**Re: First Baptist Church Addition
4101 Paseo Del Norte NW
Request Permanent C.O. - Accepted
Engineer's Stamp dated: 2-16-16 (C12D017)
Certification dated: 10-5-16**

**Re: First Baptist Church Addition
4101 Paseo Del Norte
Request Temporary 30-Day C.O. - Accepted
Engineer's Stamp dated: 2-16-16 (C12D017)
Certification dated: 8-23-16**

**RE: First Baptist Church Addition (Paseo del Norte)
Grading and Drainage Plan
Stamp Date 2/16/16 (File: C12D17)**

Re: First Baptist Church Addition, Hydrology Re-Submittal (Hydrology File C12D17)

DRAINAGE CERTIFICATION

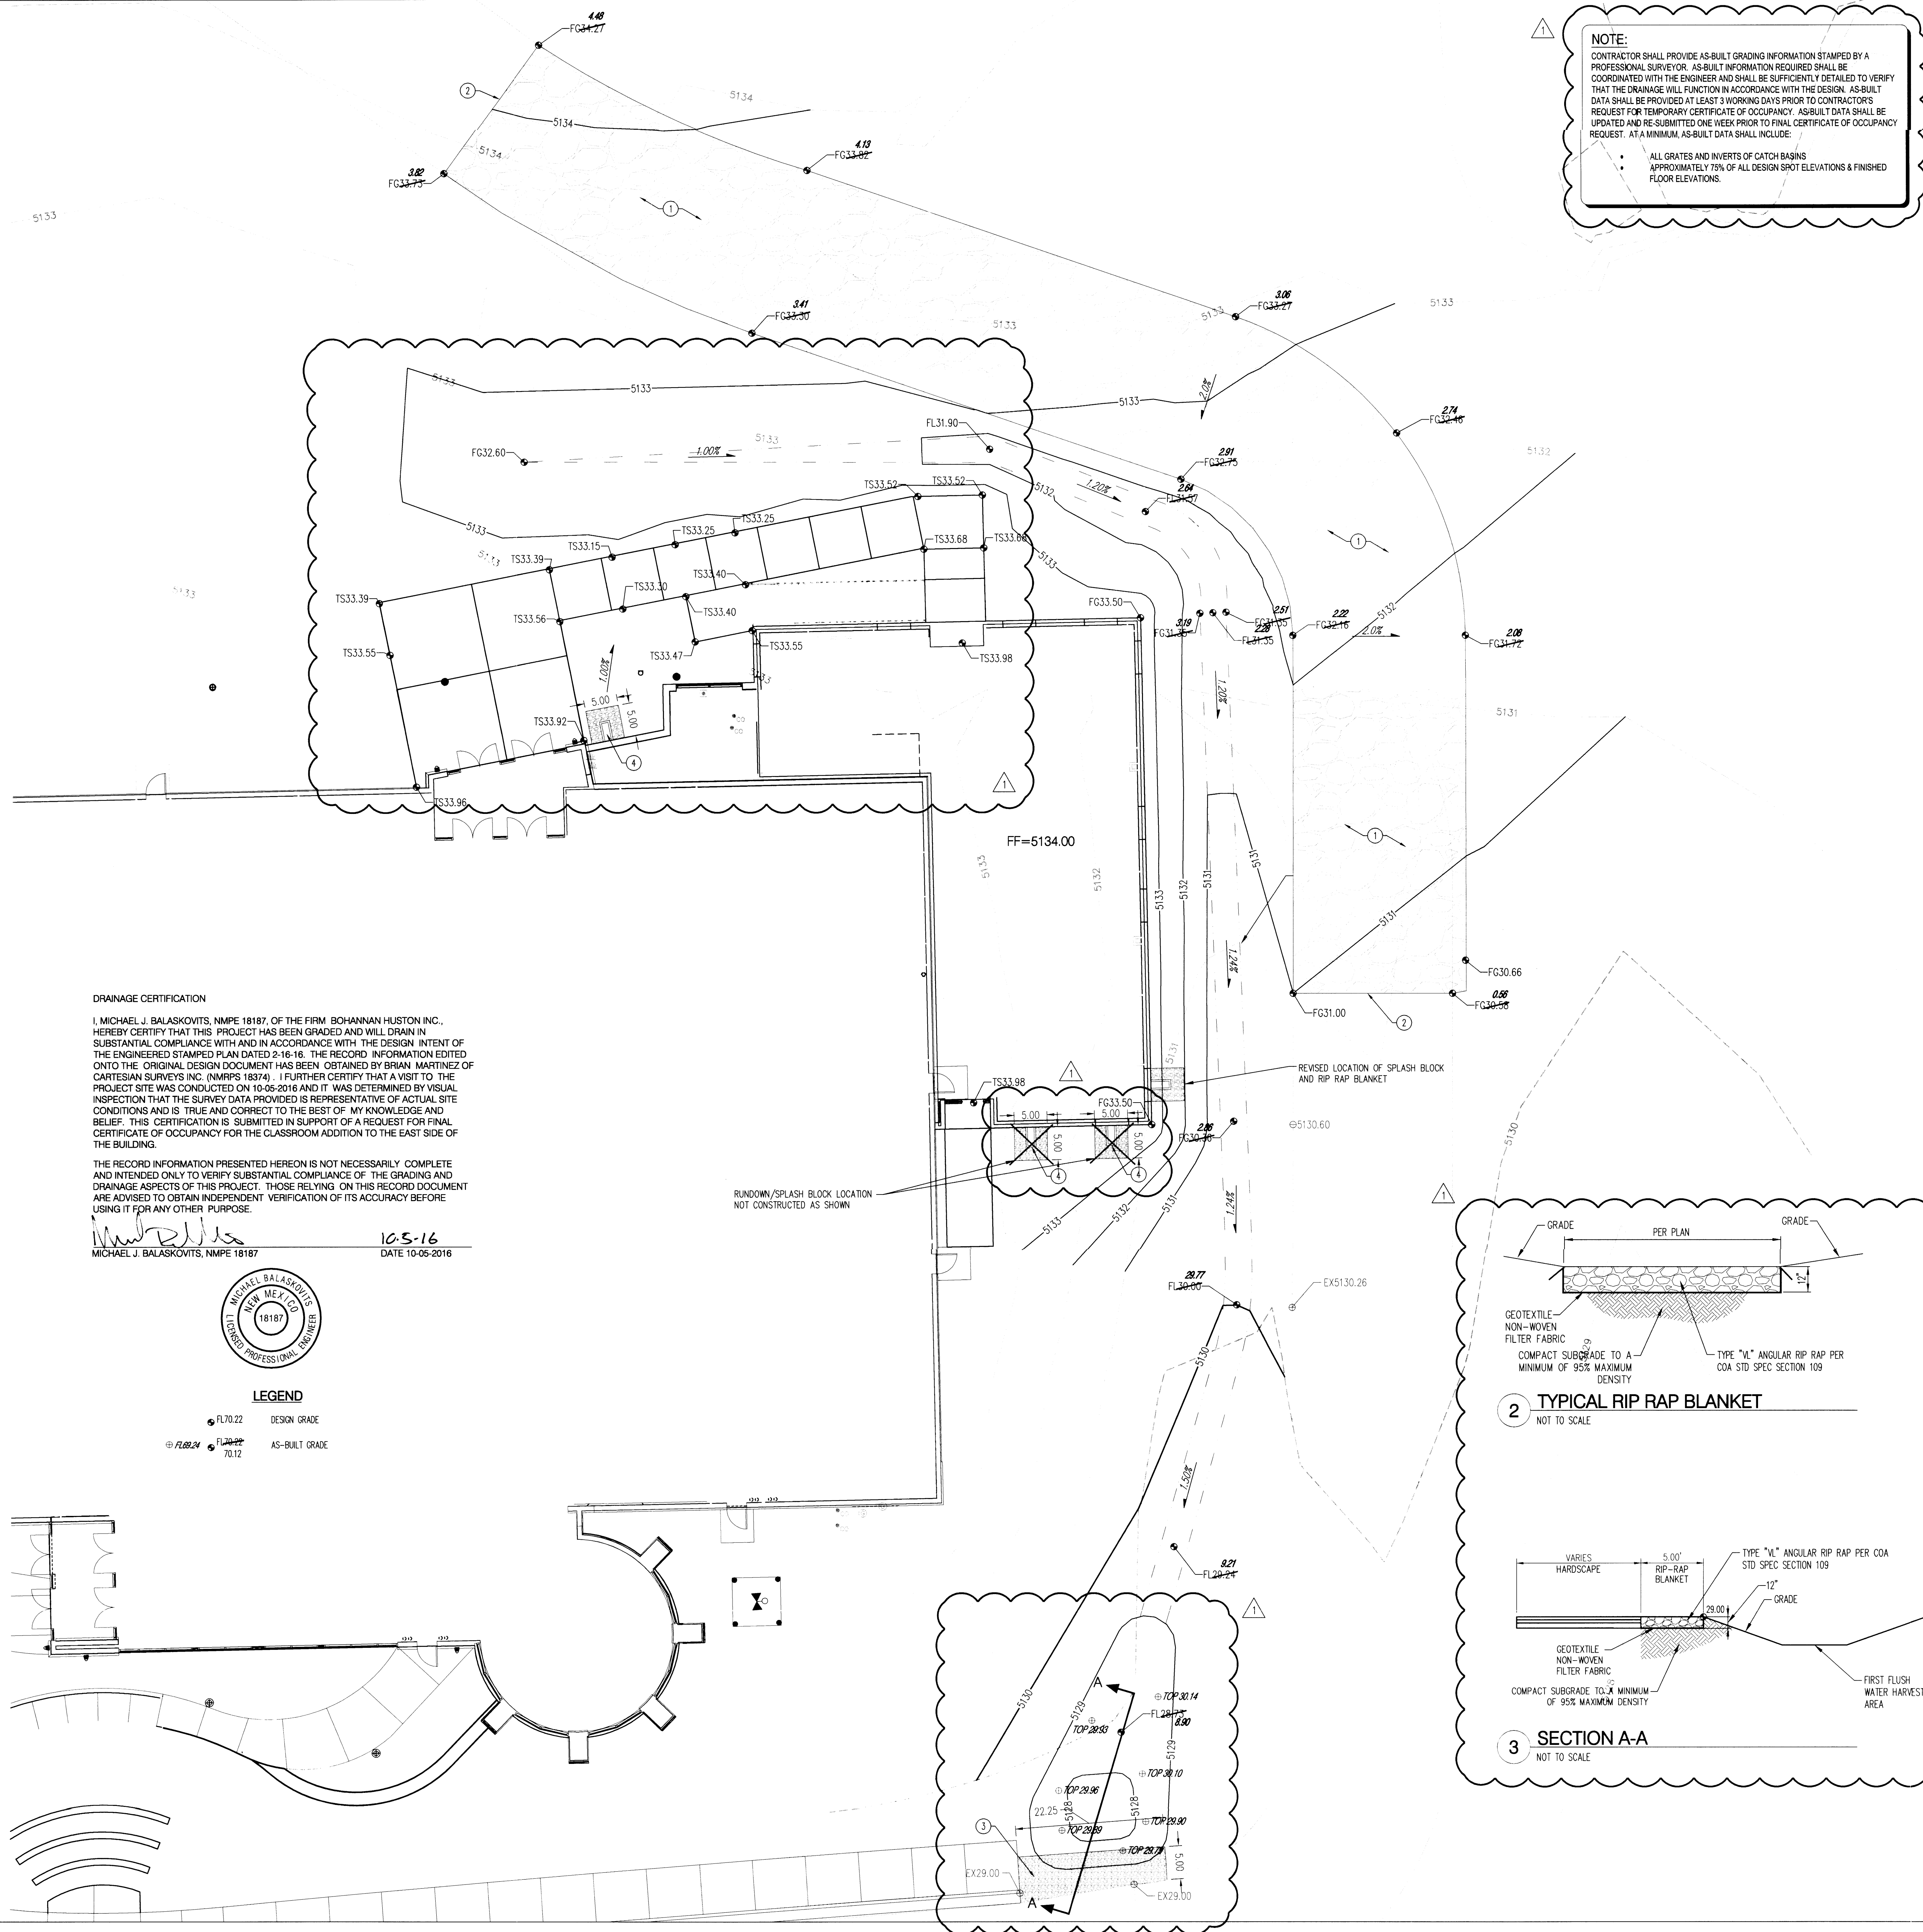
- The as-built drawing needs to reflect the actual number and location of the splash blocks.
- Geotextile non-woven filter fabric needs to be placed under the splash block and extend up around the sides. There is considerable erosion taking place underneath both splash blocks.
- The splash block on the north side of the building needs to have the rip-rap extended to all 3 sides to slow down the erosion.

2.02

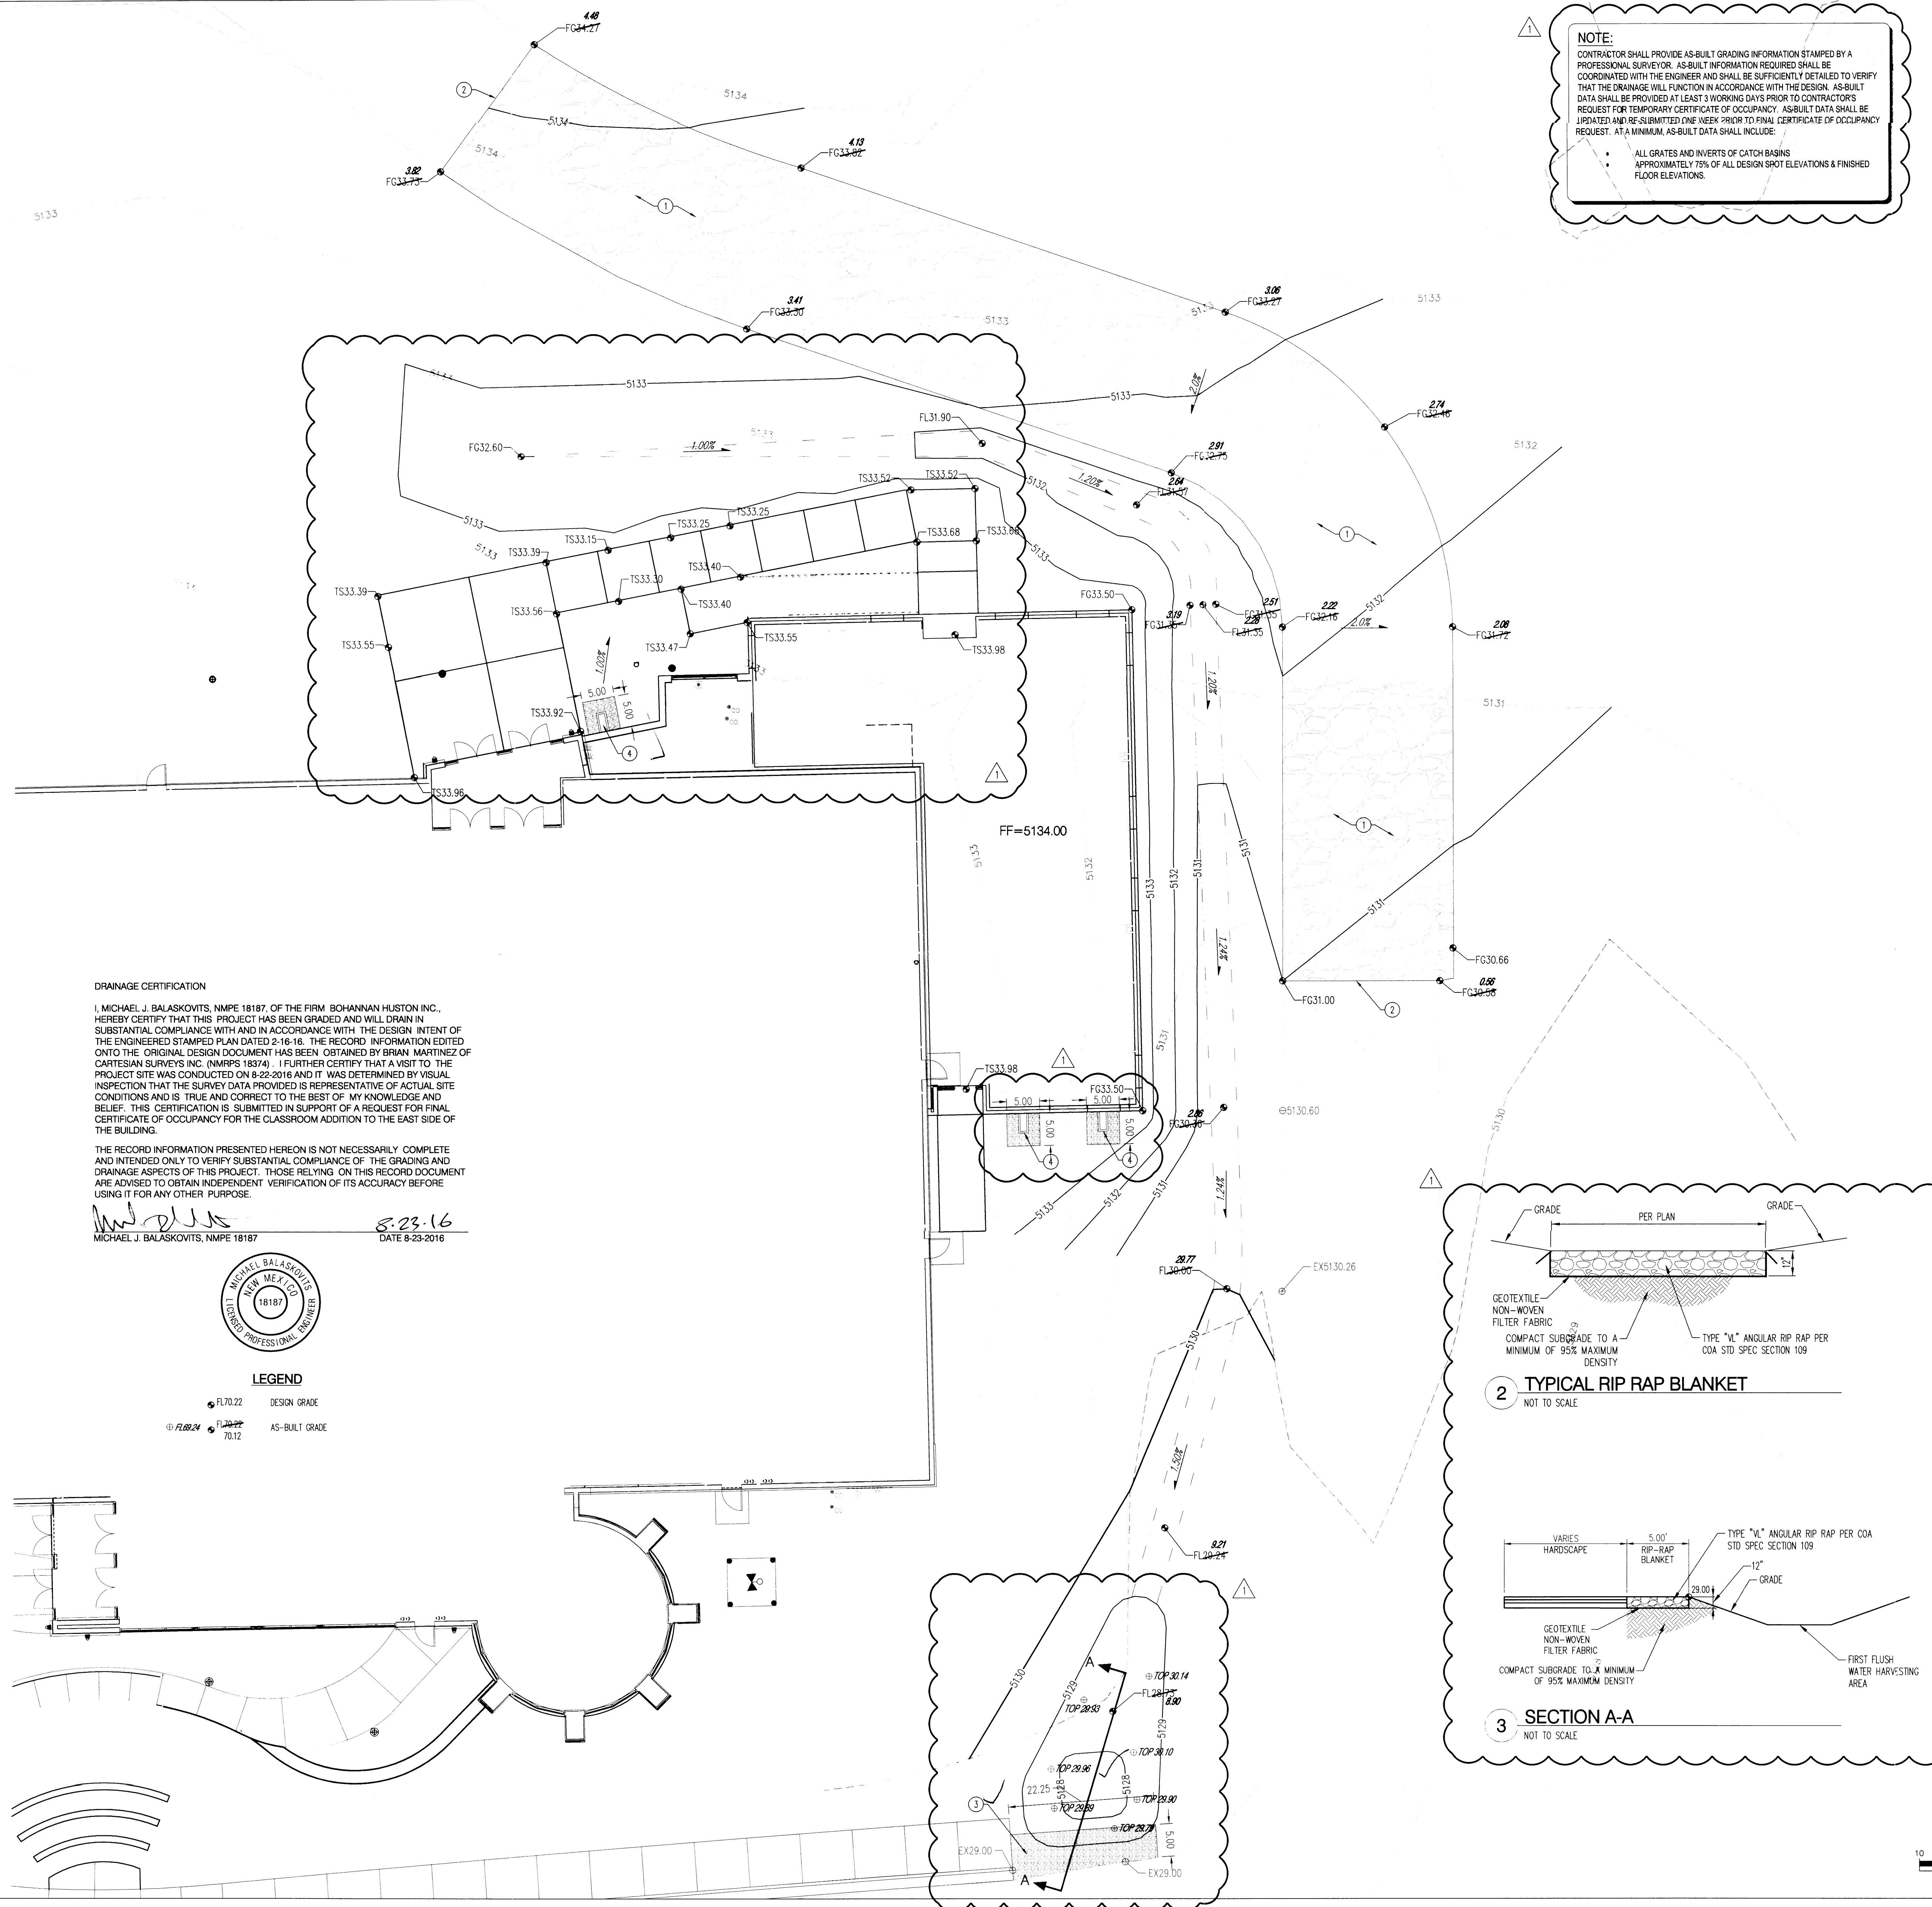
- The transition from the natural ground surfaces to the paved parking lot outfall is subject to erosion and sediment transfer to the City's storm drain system. Permanent BMPs should be planned at the eastern edge of the paved parking lot, since Basin 1-2 will not be fully developed in the near future. Alternatively, the first flush volume pond could be relocated as close as practicable to the edge of the parking lot to double as a de-siltation pond (this option would be preferred, but any BMP suggestion would be considered).
- Informational Comment: The first flush volume will need to be maintained throughout future additions and developments of this basin.

1. The First Flush Volume Pond was moved to the edge of the southern parking lot to double as a de-siltation pond as requested. A rip rap blanket will be provided where the pond and the hardscape meet to prevent any erosion. A detail was provided showing the relationship between the pond, rip rap, and parking lot hardscape. See sheet C2.01 for more details.
2. In response to informational comment, the previously approved DRB plans and conceptual grading and drainage sheets did not adhere to the First Flush requirements due to the date at which it was approved. All possible considerations to retain the First Flush for future development will be taken into account.
3. The revision clouds shown are for the use of the contractor. Spot elevations and roof drain locations changed since the previous submittal but still ultimately outfall into the swale and First Flush Volume Pond.
